BL-26-00003 lies within the Kittitas Reclamation District (KRD) service area and will be required to meet the KRD's subdivision guidelines. Please have the landowner contact KRD for more information.

**Subject:** BL-26-00003 Hanson - Notice of Application

**TO:** All Staff  
**FROM:** Public Works Plan Review Team  
**DATE:** March 25, 2026  
**SUBJECT:** BL-26-00003 Hanson

HANSON BLA

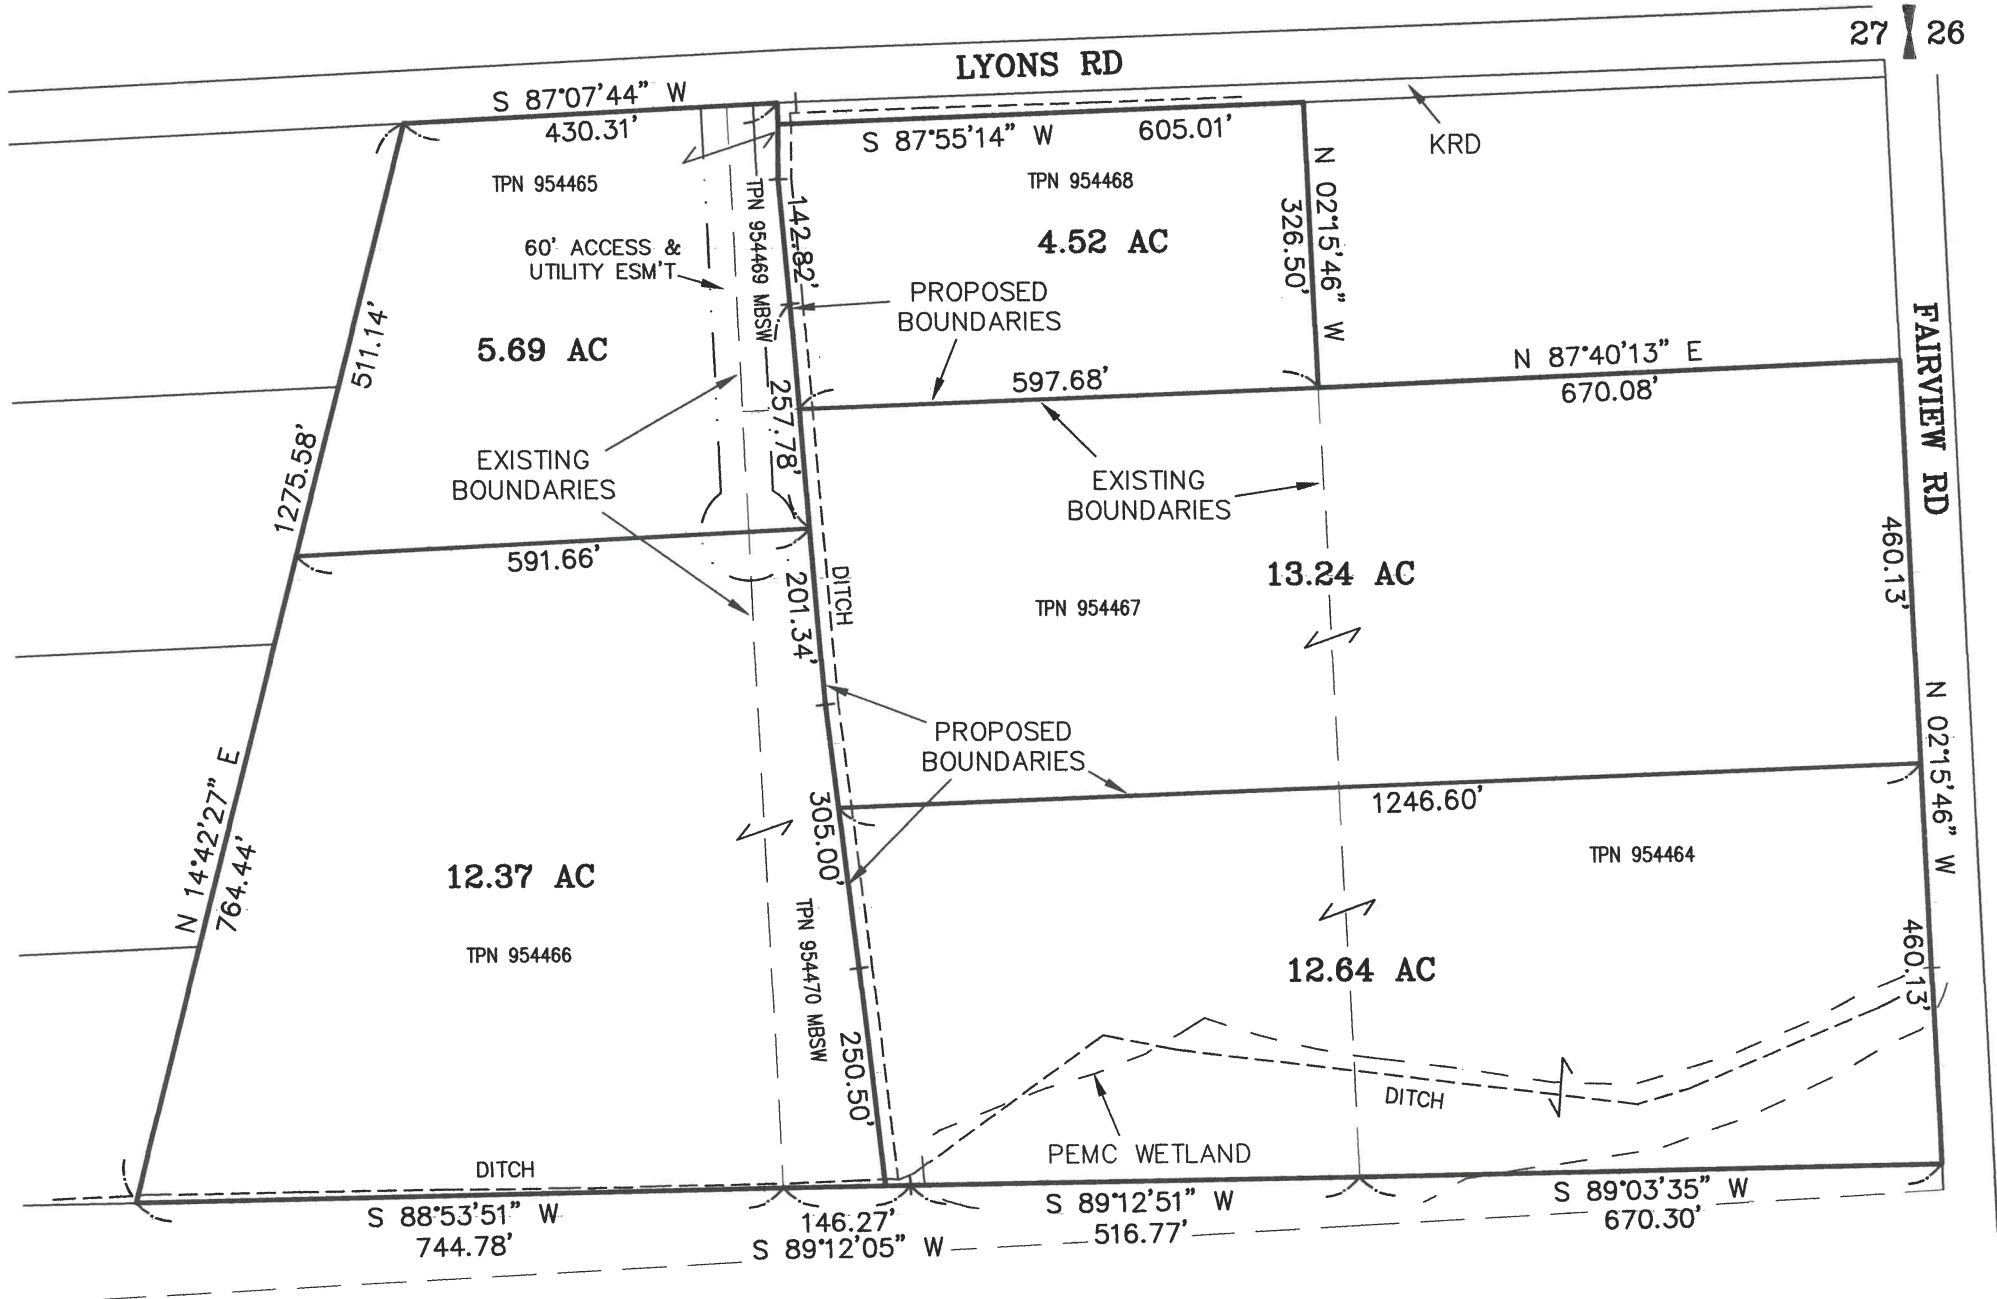
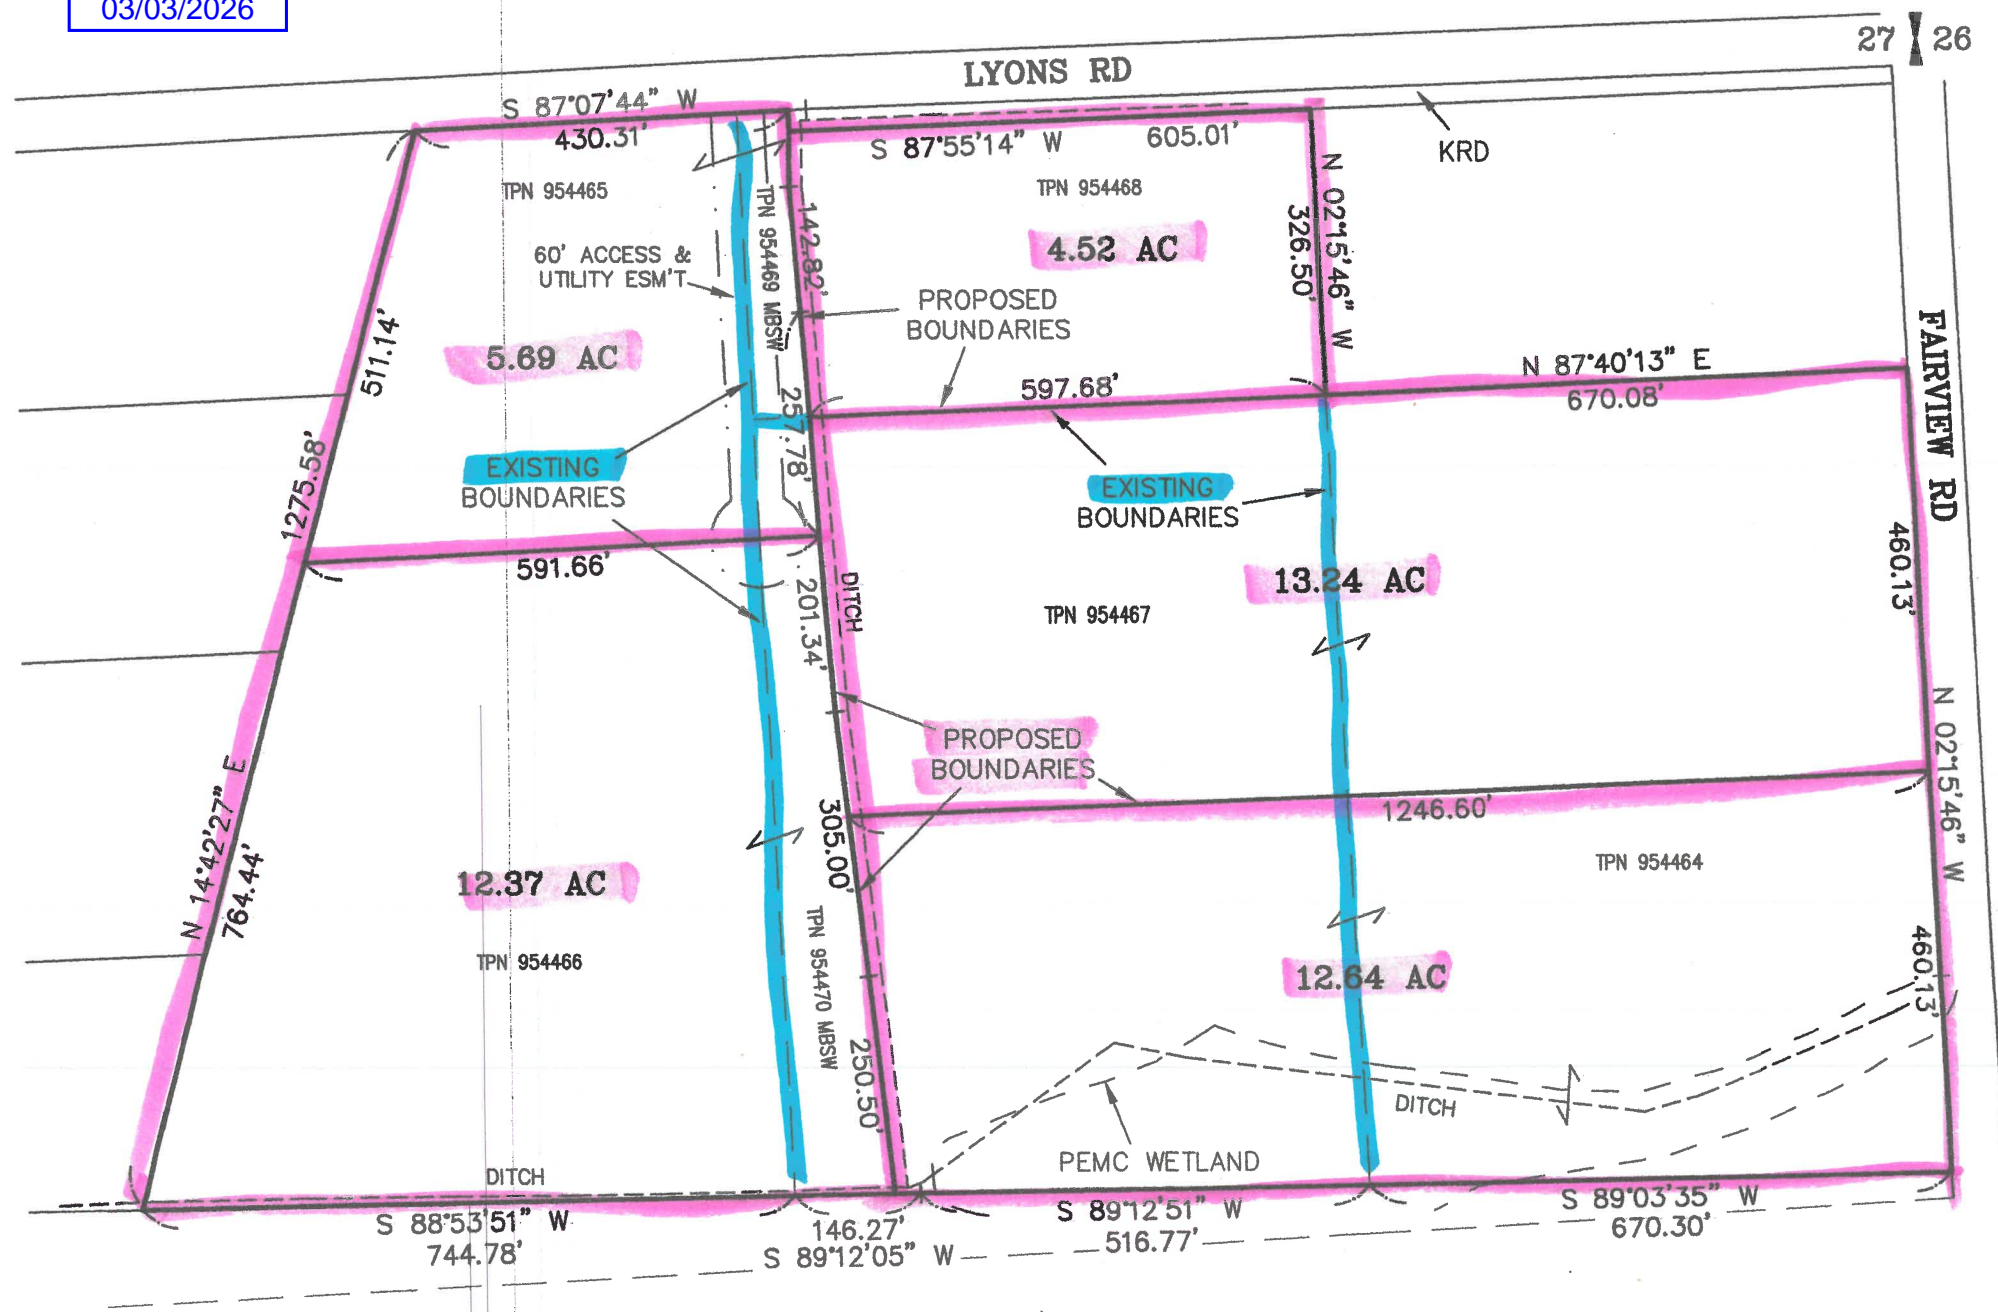
<b>ACCESS</b>	<ol style="list-style-type: none"> <li>1. Provide easements for access to lots from joint-use driveways. Lyons Road and Fairview Road have an access spacing of 300 feet between driveways on the same side of the road.</li> <li>2. An approved access permit shall be required from the Kittitas County Department of Public Works prior to creating any new driveway access or altering existing access.</li> <li>3. Maintenance of driveway approaches shall be the responsibility of the owner whose property they serve. The County will not maintain accesses.</li> <li>4. Any further subdivision or lots to be served by proposed access may result in further access requirements. See Kittitas County Road Standards.</li> </ol> <p>In addition to the above-mentioned conditions, all applicable Kittitas County Road Standards apply to this proposal. Access is not guaranteed to any existing or created parcel on this application. (RC)</p>
